COMBINED PRELIMINARY AND FINAL  
DRAINAGE REPORT  
for  
OHANA SUBDIVISION  
EL PASO COUNTY, COLORADO

Allison Engineering  
4245 Log Road  
Peyton, CO 80831

FINAL PLAT OHANA ACRES

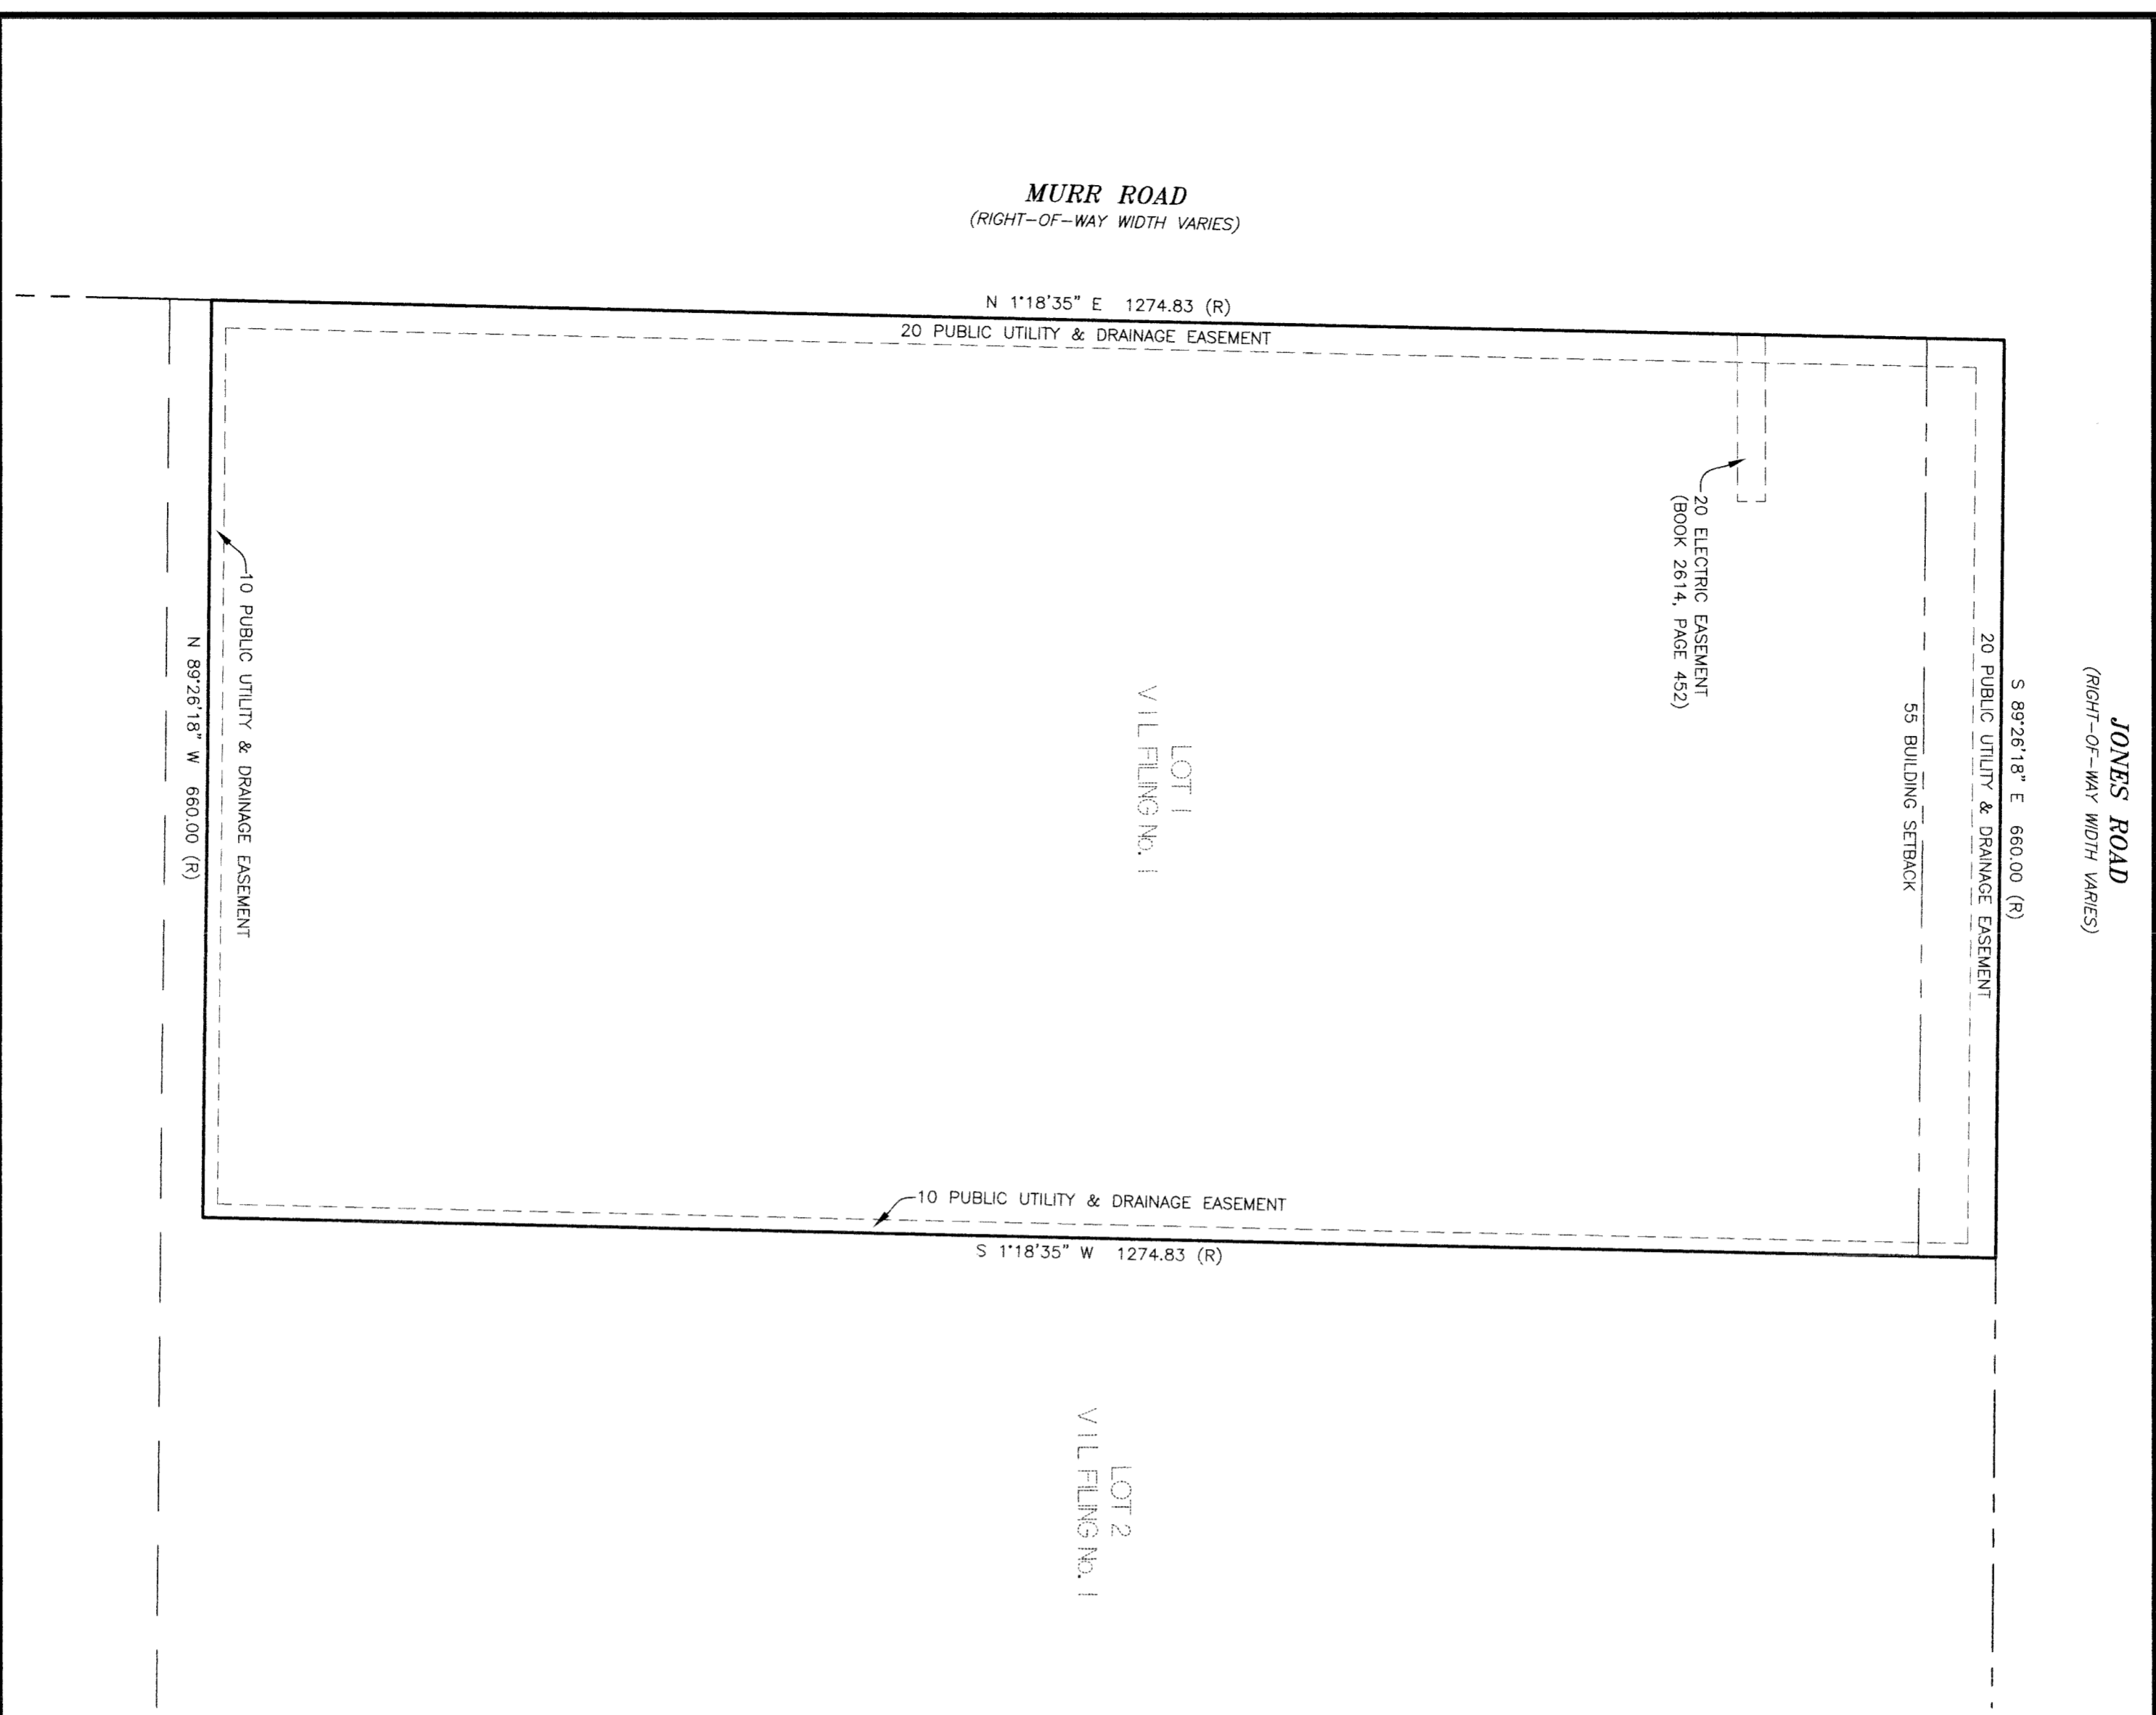
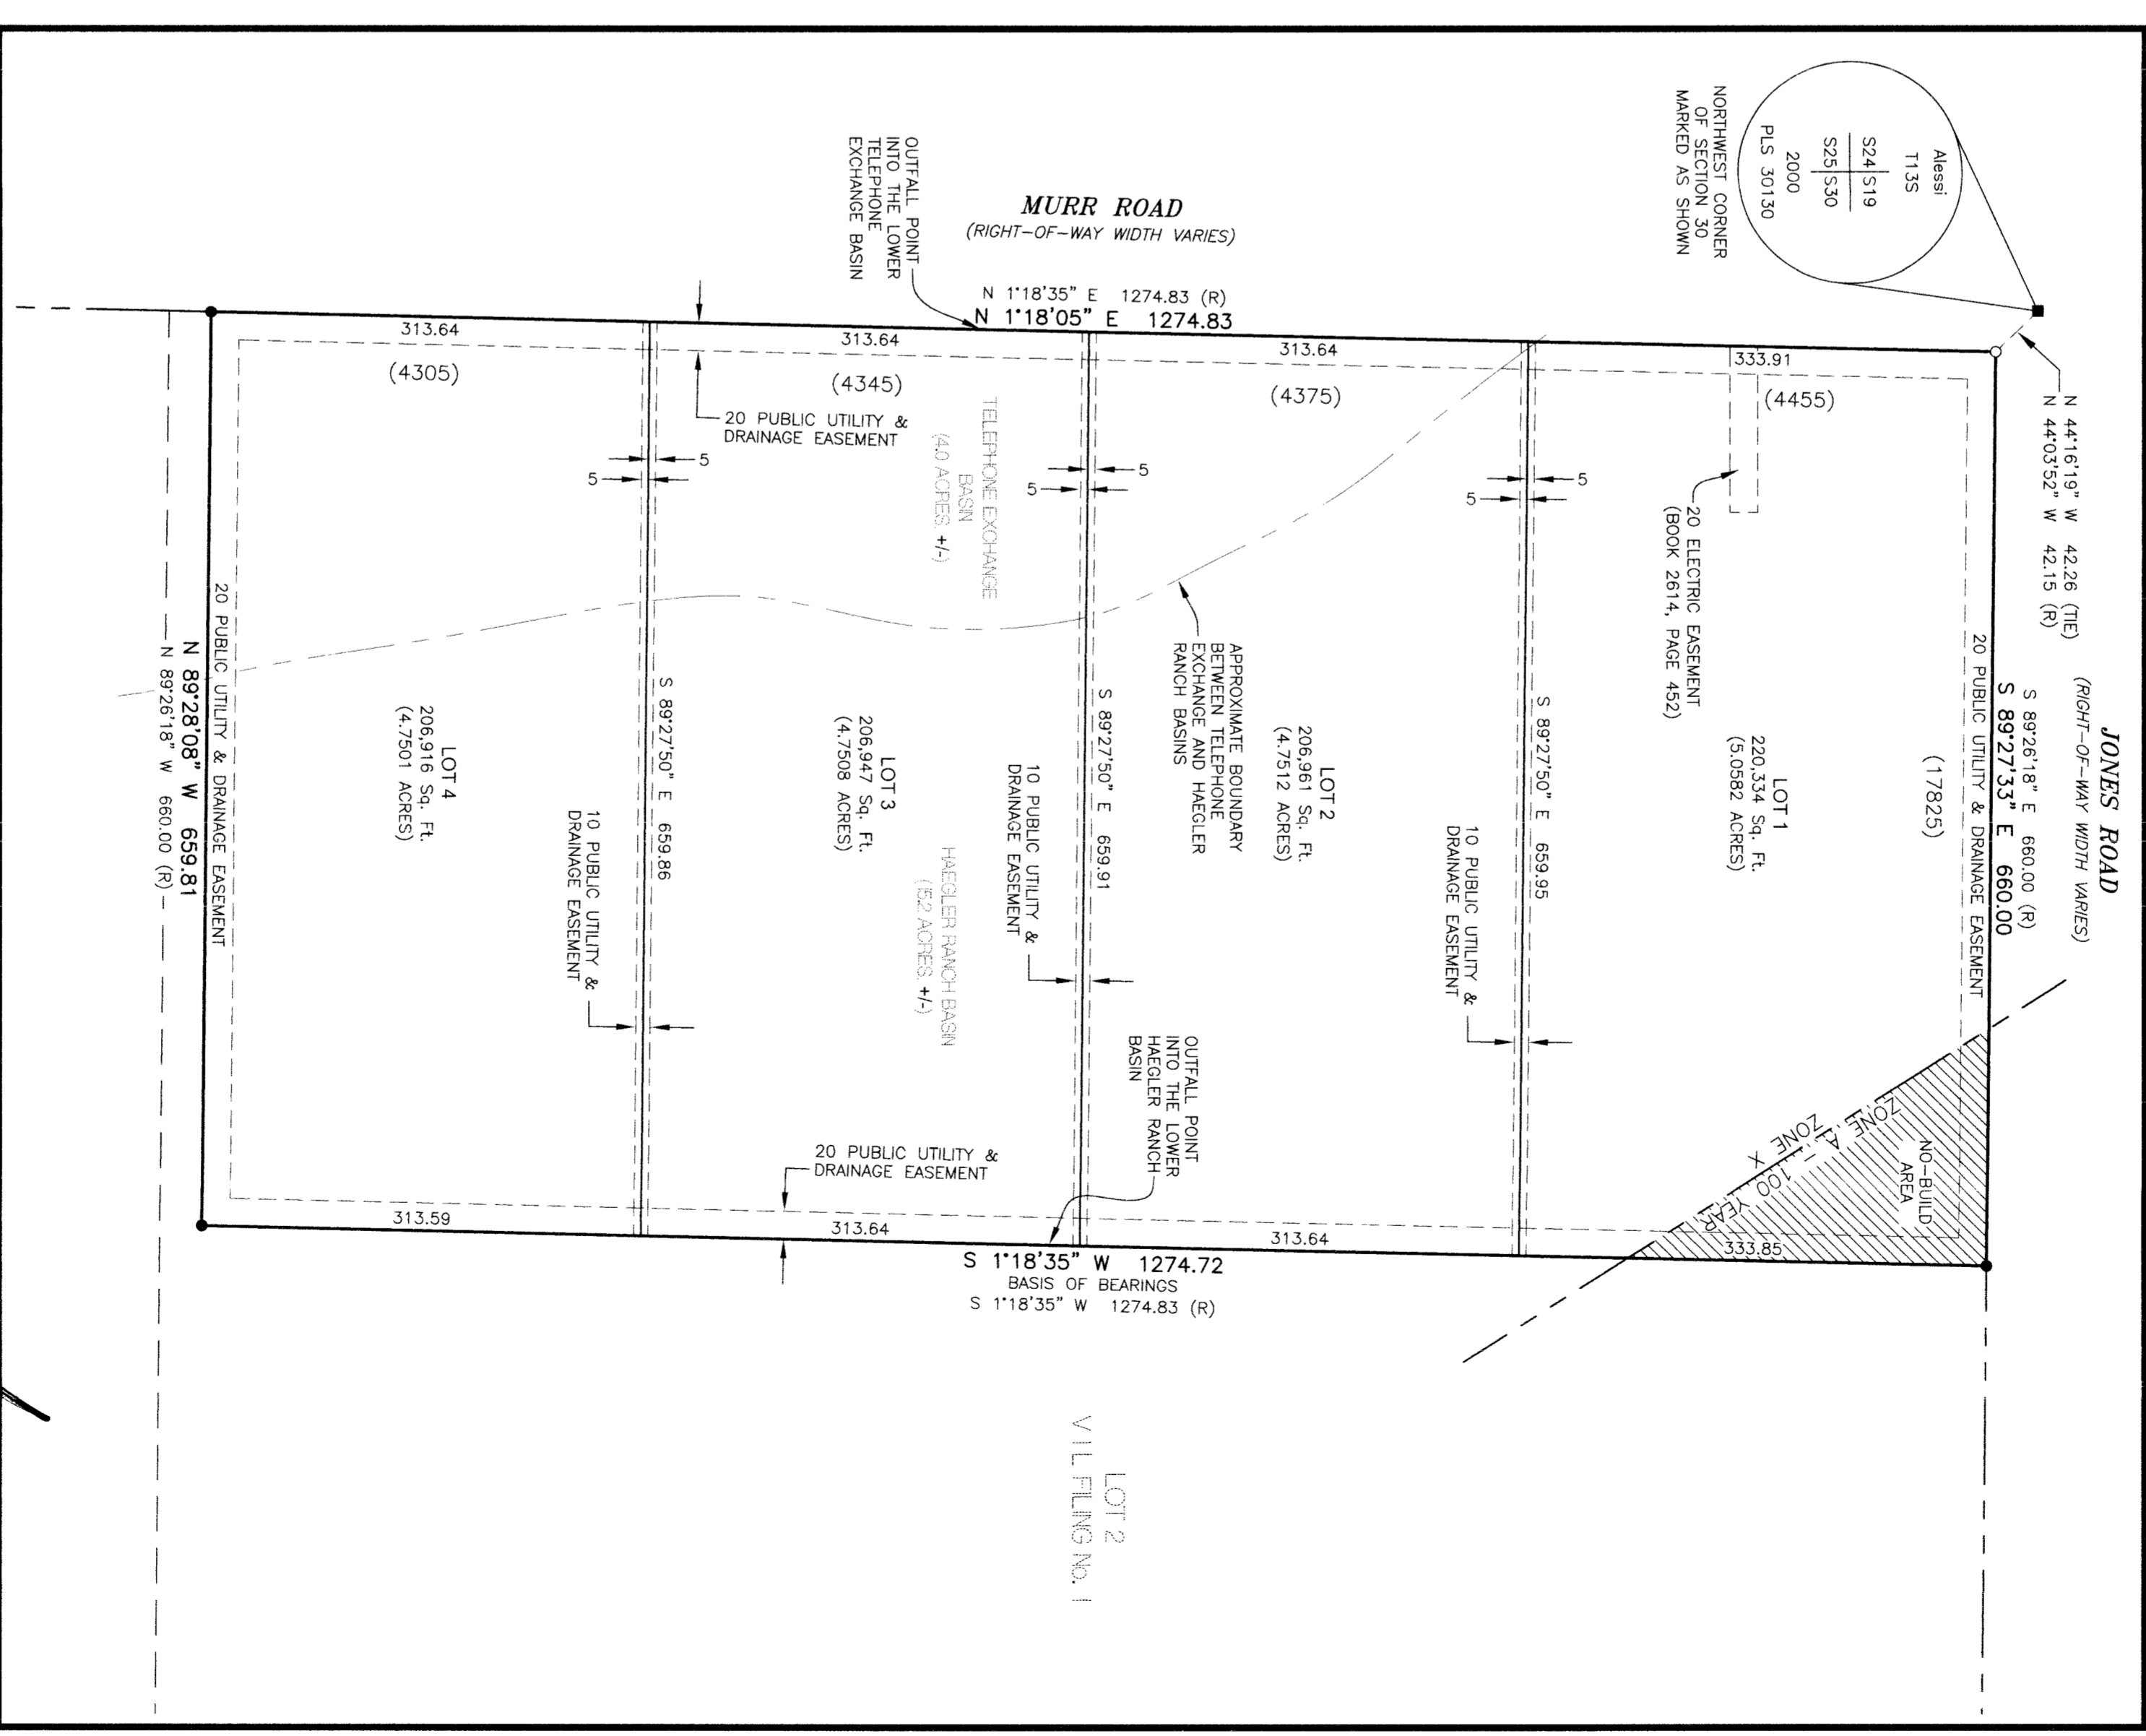
Drainage Map needs to show boundary between Telephone Exchange & Haegler Ranch basins.
